East Pye Solar (EN0110014): Deadline 1 Written Representation

White-clawed crayfish and the River Tas: request for statutory advice, and response to the Applicant's Position Statement on White-Clawed Crayfish (EXAM/8.5, EN0110014)

Ross Jolliffe, Interested Party registration [REDACTED]

28/09/2026

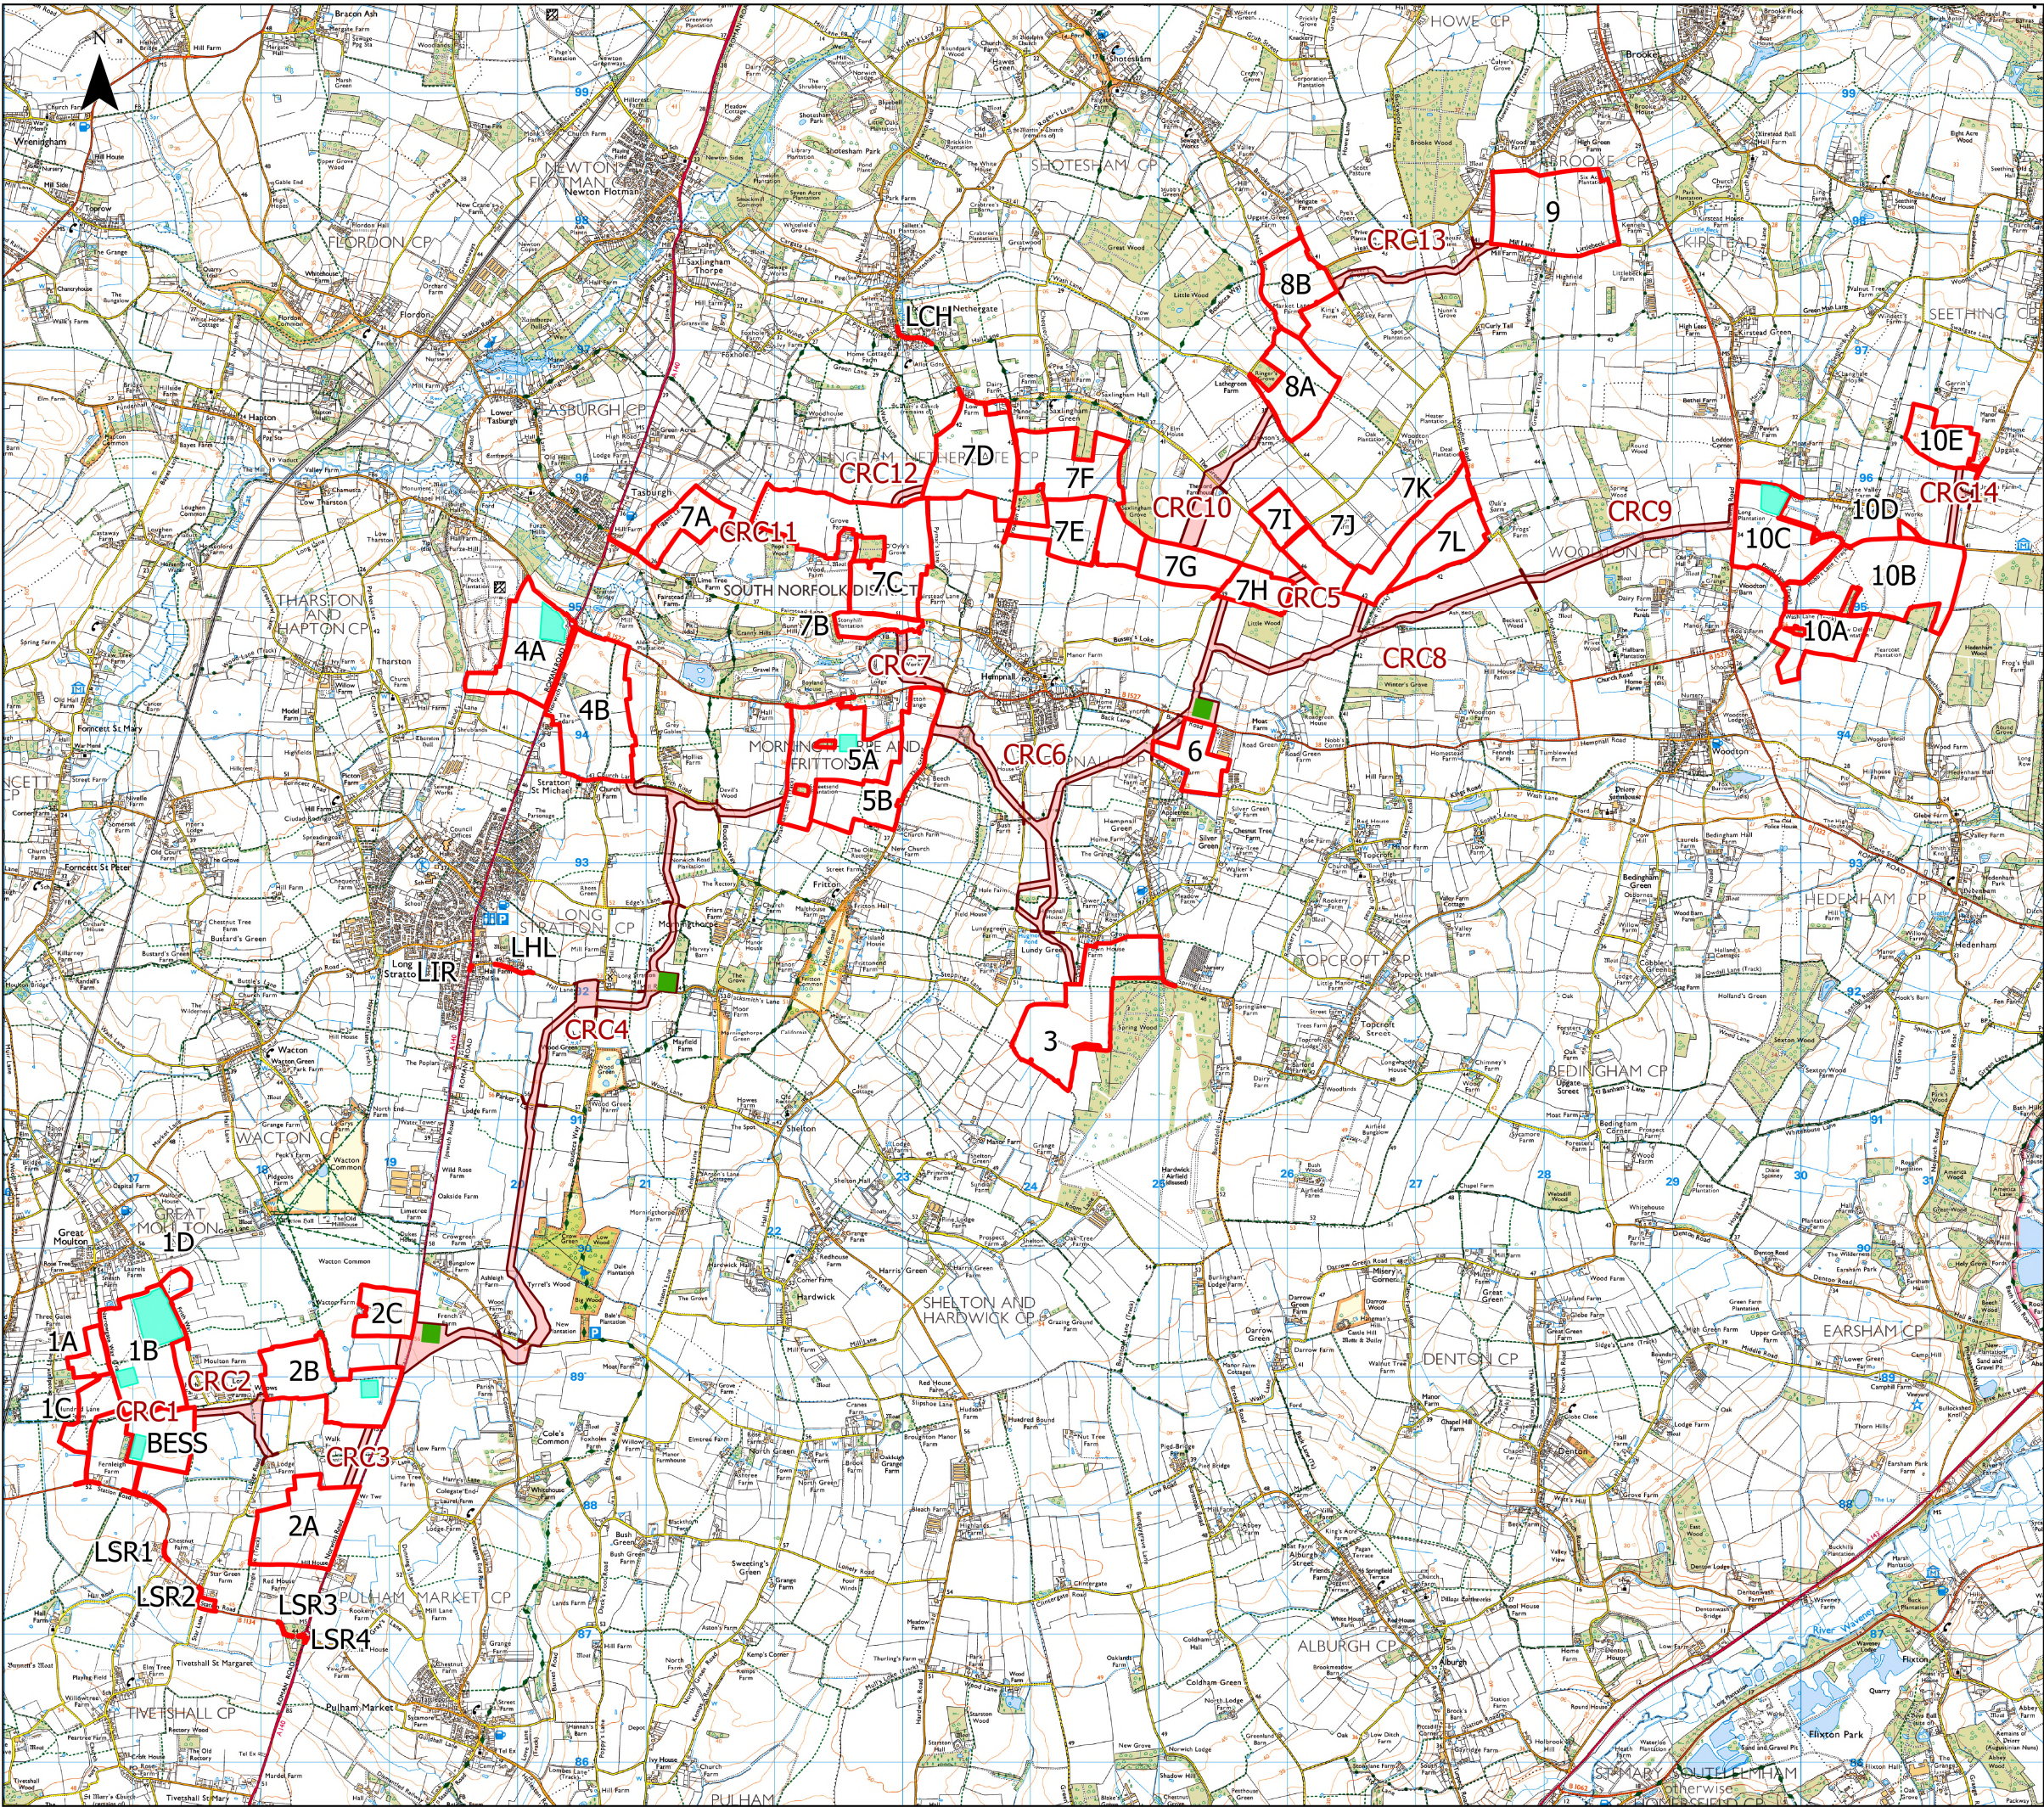
‘Inadequate habitat enhancement’: the Applicant has made reference to habitat enhancement. I commented that these are small-scale and there is no detailed baseline evidence against which to verify change. There is evidence that the construction period, with great disruption, is not considered properly, for example site 6, habitat management is to be used as a site compound.
